27 July 2026

Re: Objection to State Significant Development Application SSD-119545240 – Residential Flat Buildings at 40-76 William Street, Leichhardt

1 North Elevation  
SCALE 1:200

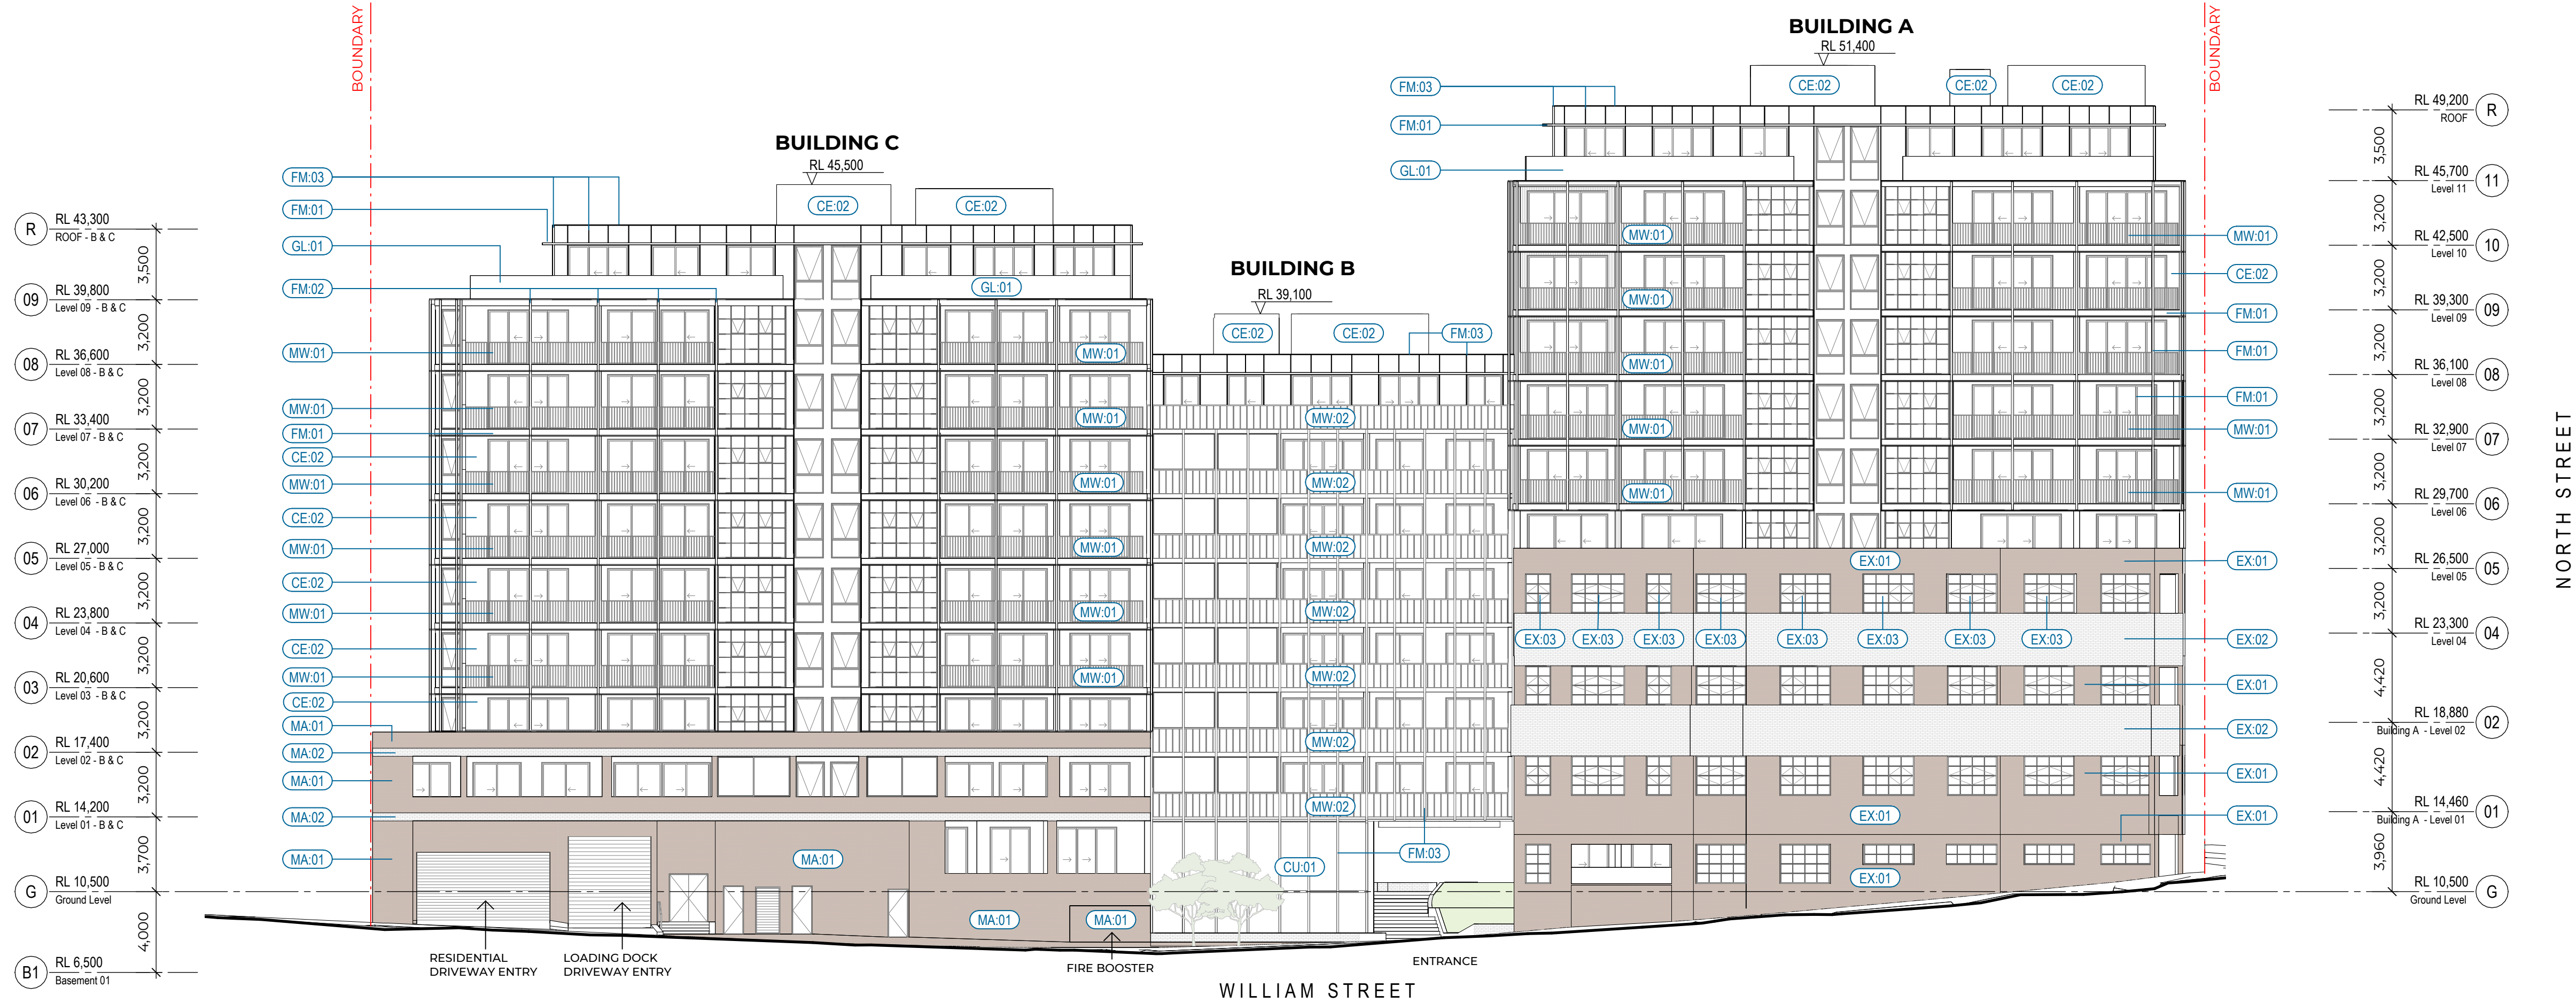
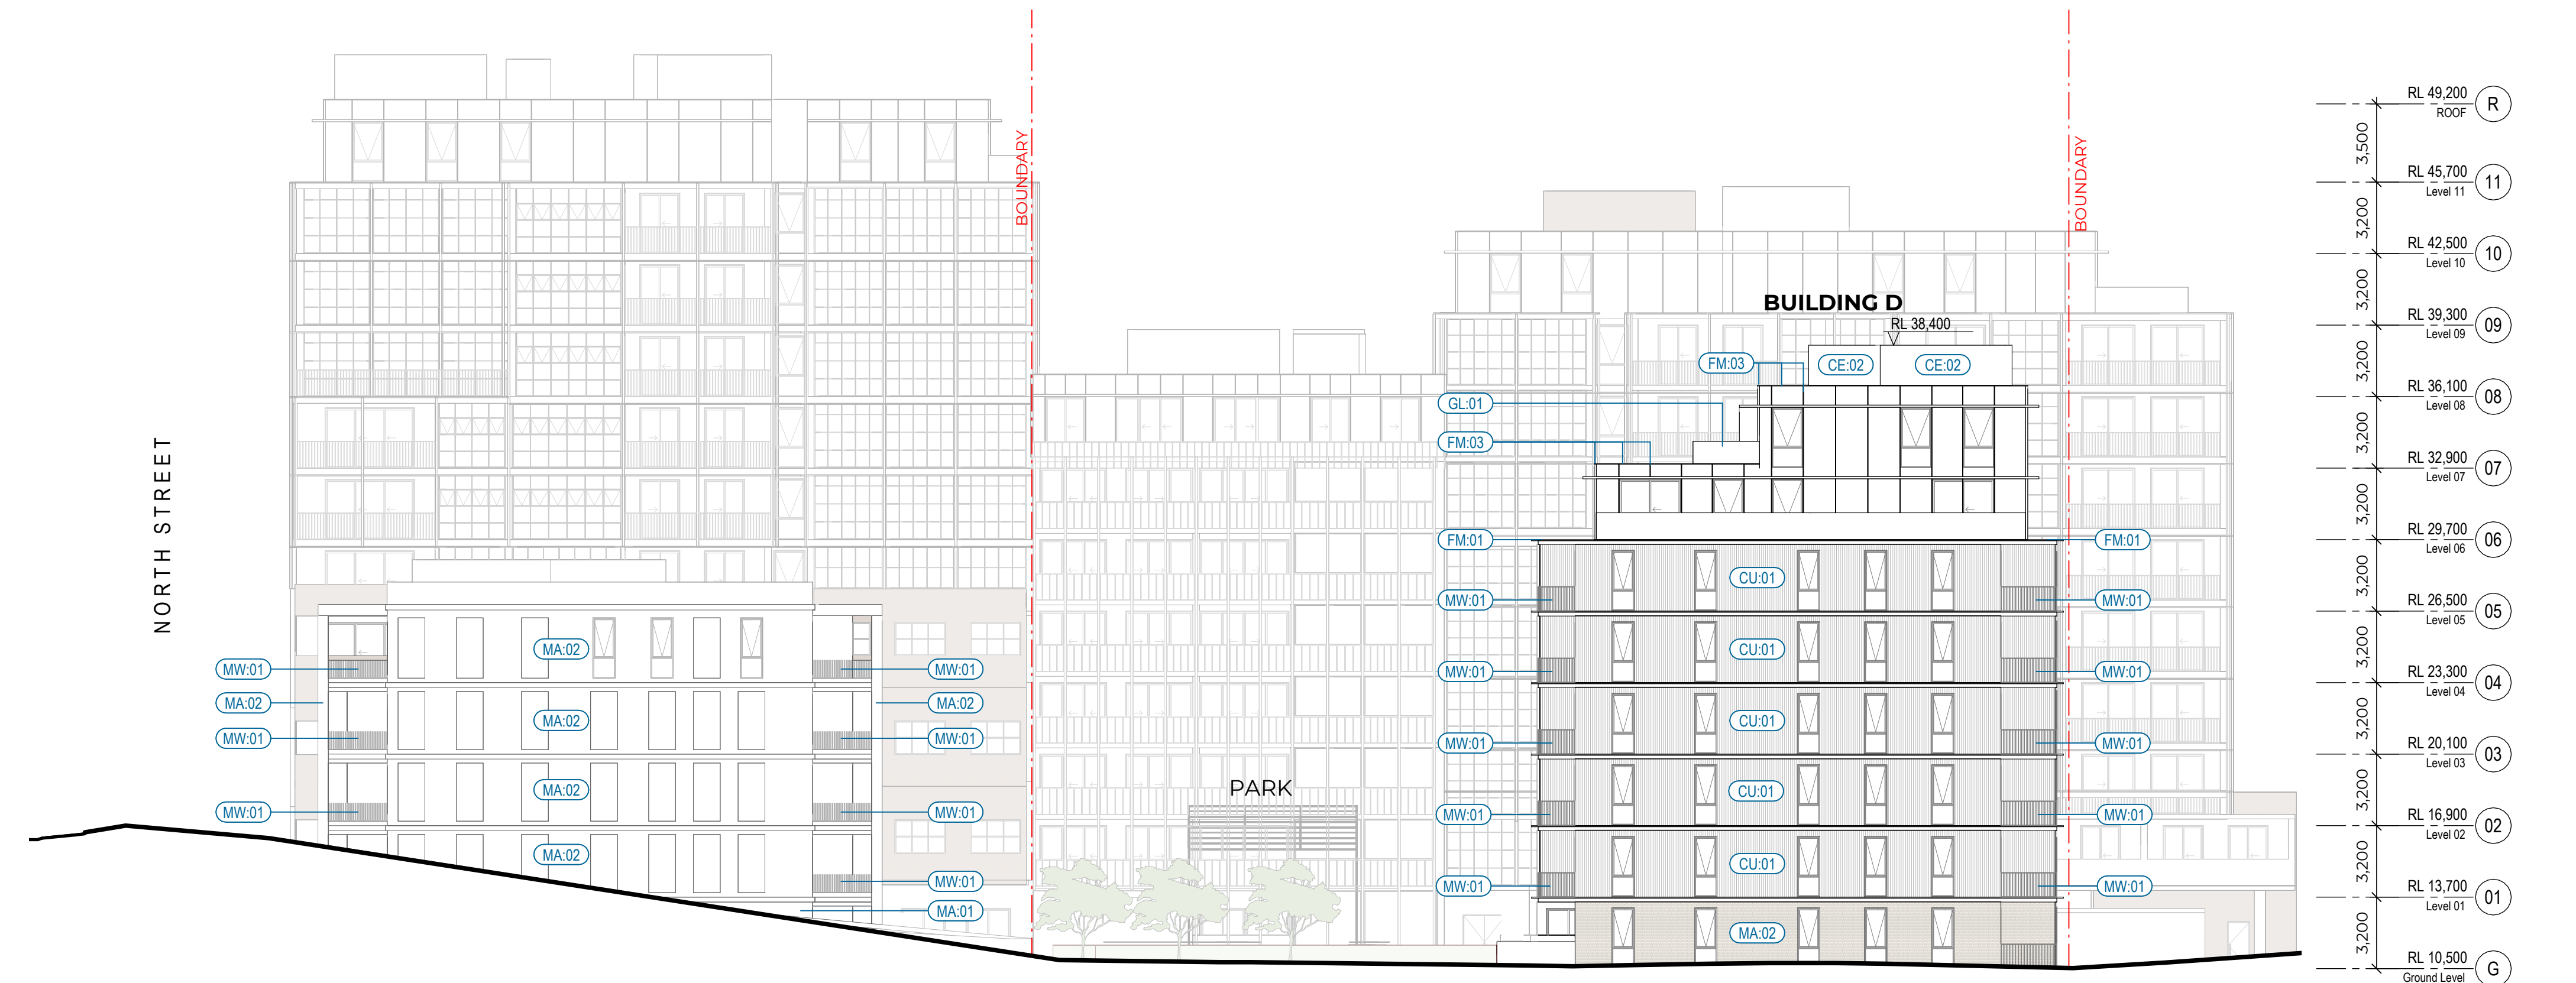
William Street and the streets around it are a consistent run of one and two storey Victorian terraces. The applicant's own stamped plans show the tallest building, Building A, sitting on the William Street frontage and rising to a roof level of RL 45.7, which is about 35 metres above the ground floor. That is more than four times the height of the two storey terraces directly across the road. Dropping something of that scale into this street would overshadow neighbours, tower over the terraces, and open the door to more of the same across a low rise neighbourhood.

The elevations and photomontages in the application make the building look smaller and further away than it will be. They are drawn from a distance and shown against the sky, not against the

little terraces it will loom over. They do not show what it will actually feel like to stand in William Street and look up at it.

- A real reduction in the height and number of storeys, down to a scale that sits with the terraces on William Street and this incredibly important conservation area, and enough to meet the sunlight and separation rules without relying on screens. The development should fit within the current envelope of the building that already sits on the site.
